Lazy Y Rockin' J RVP, RVP-23-1

Please accept the following comments from El Paso County Public Health (EPCPH) regarding the rezone project referenced above:

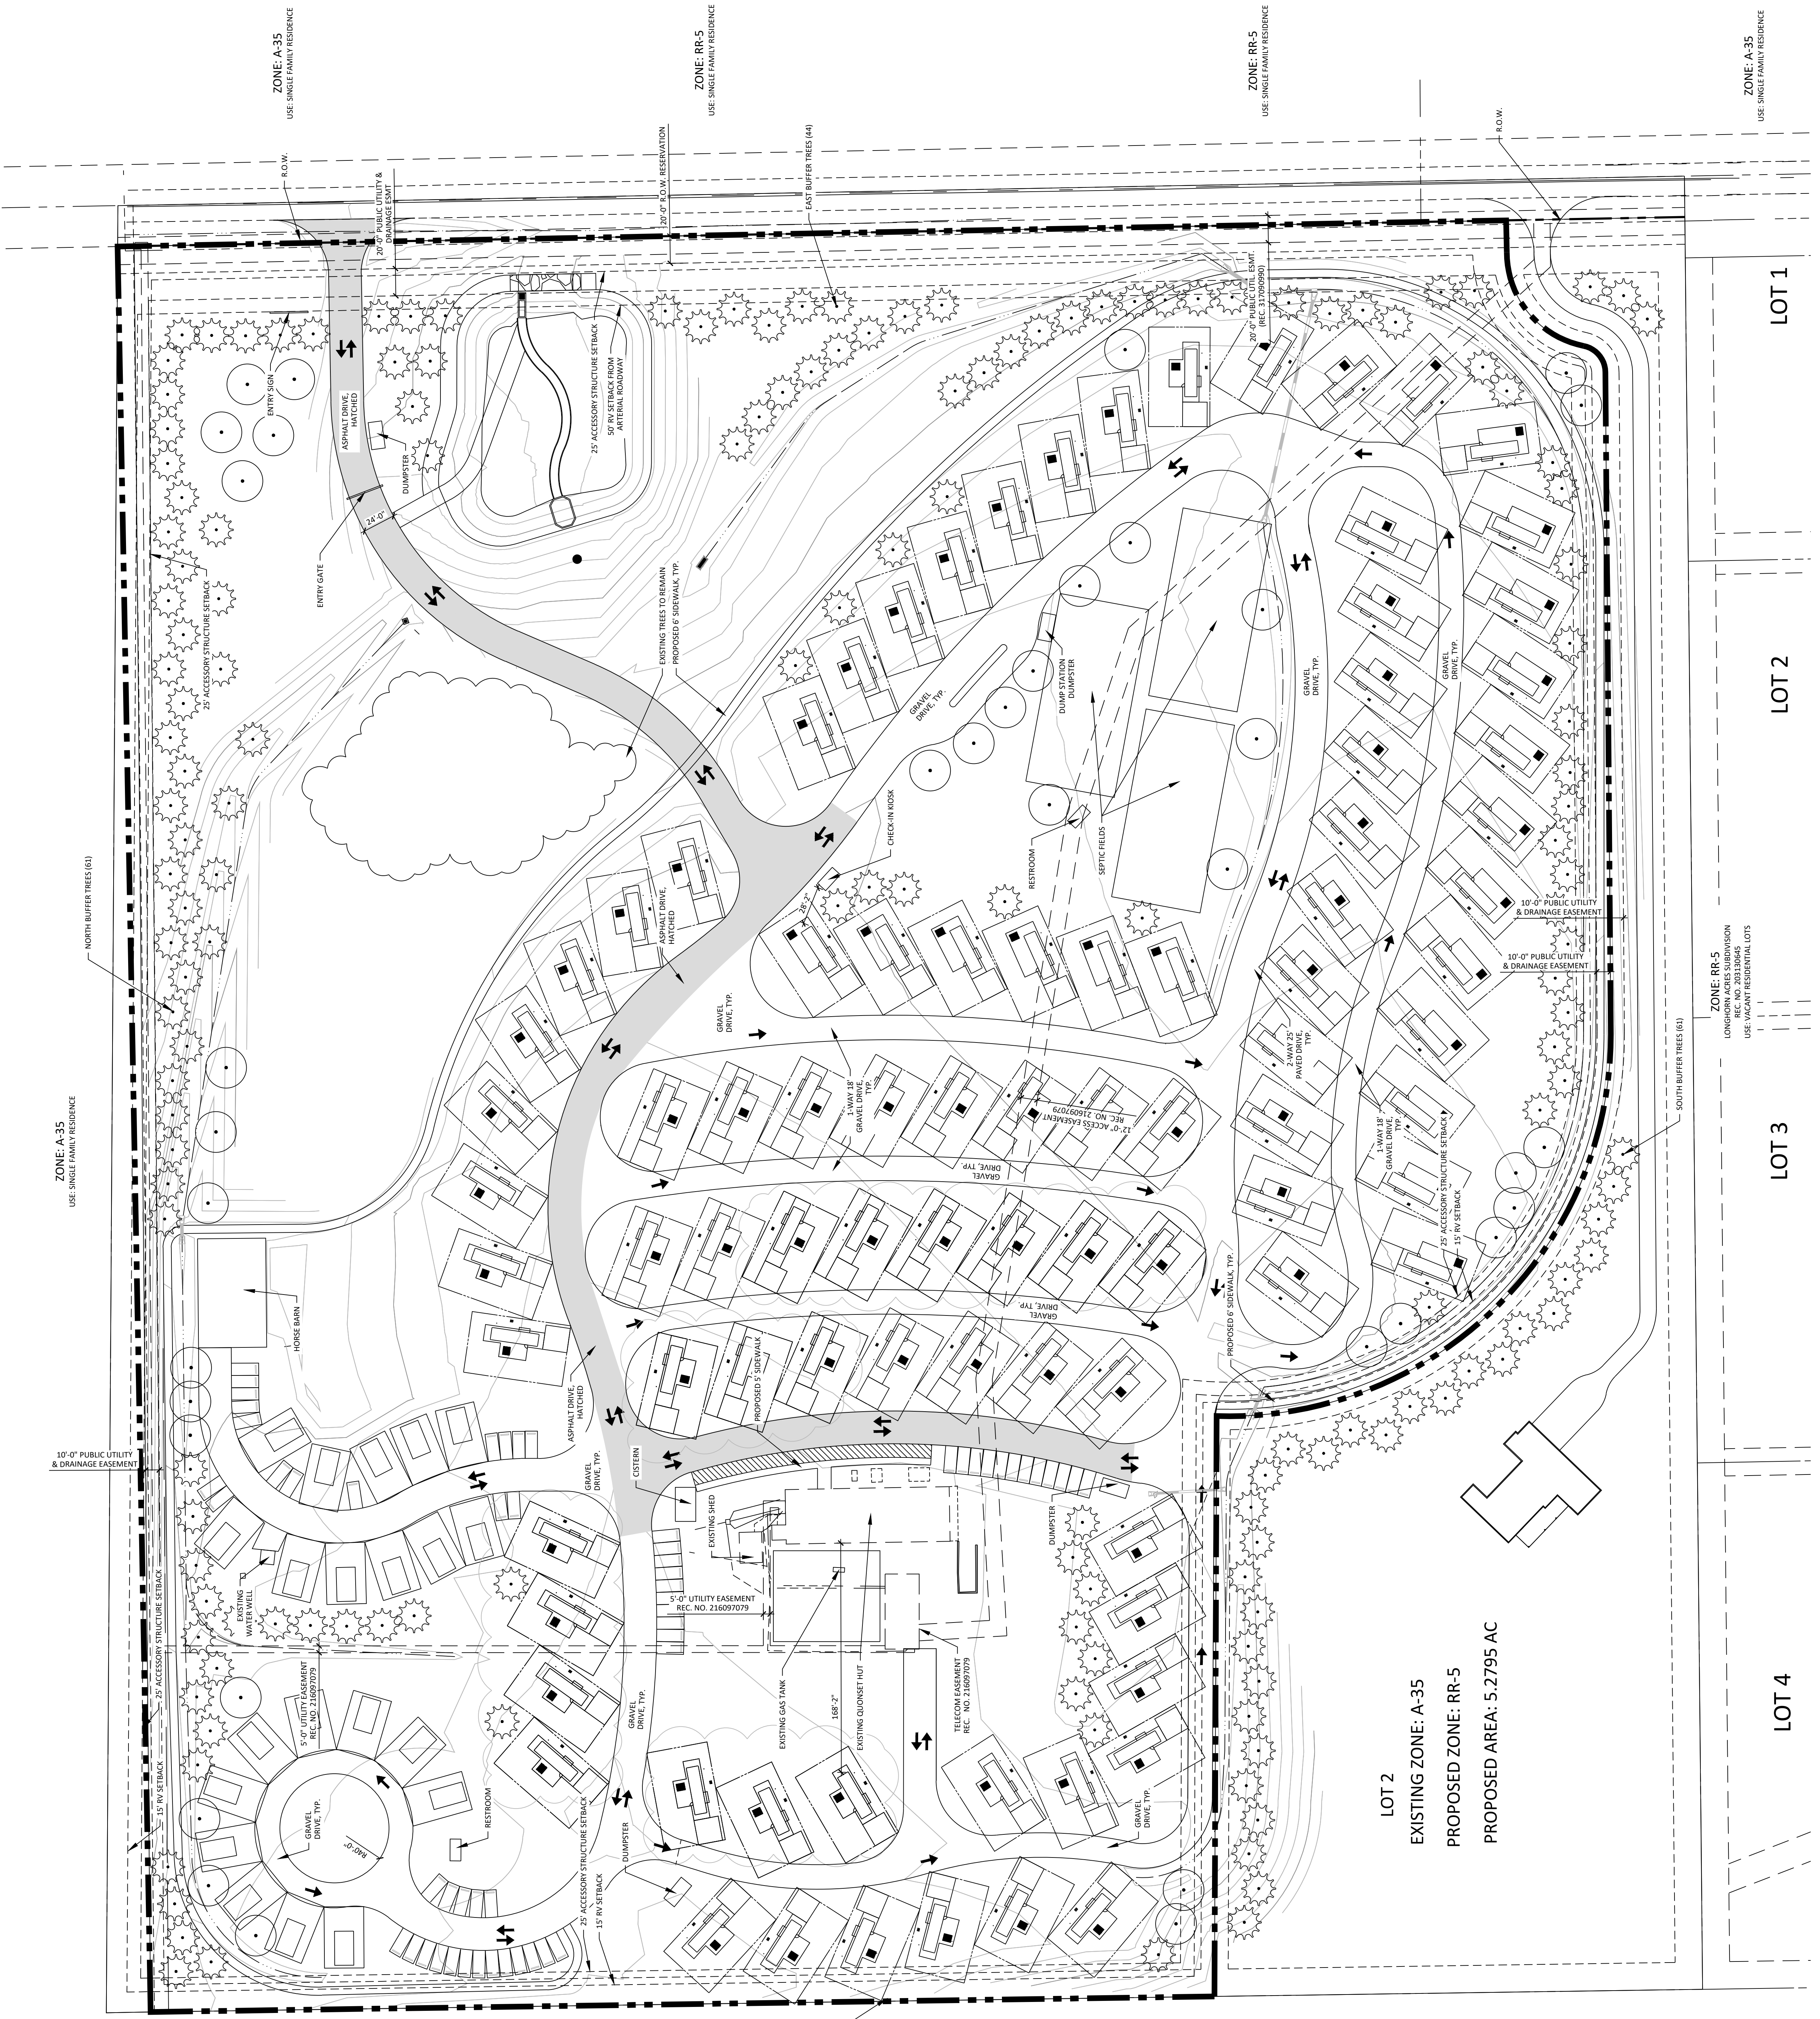
- The layout of RV spaces appears intense if water and wastewater connections are planned for each space. There are also a few restrooms on the RVP Site Plan with no estimated use calculations. Actual wastewater flows and OWTS design calculations submitted by a Colorado Registered Professional Engineer and approved by EPCPH will be necessary at the time of the Site Development Plan and Final Plat submittals.
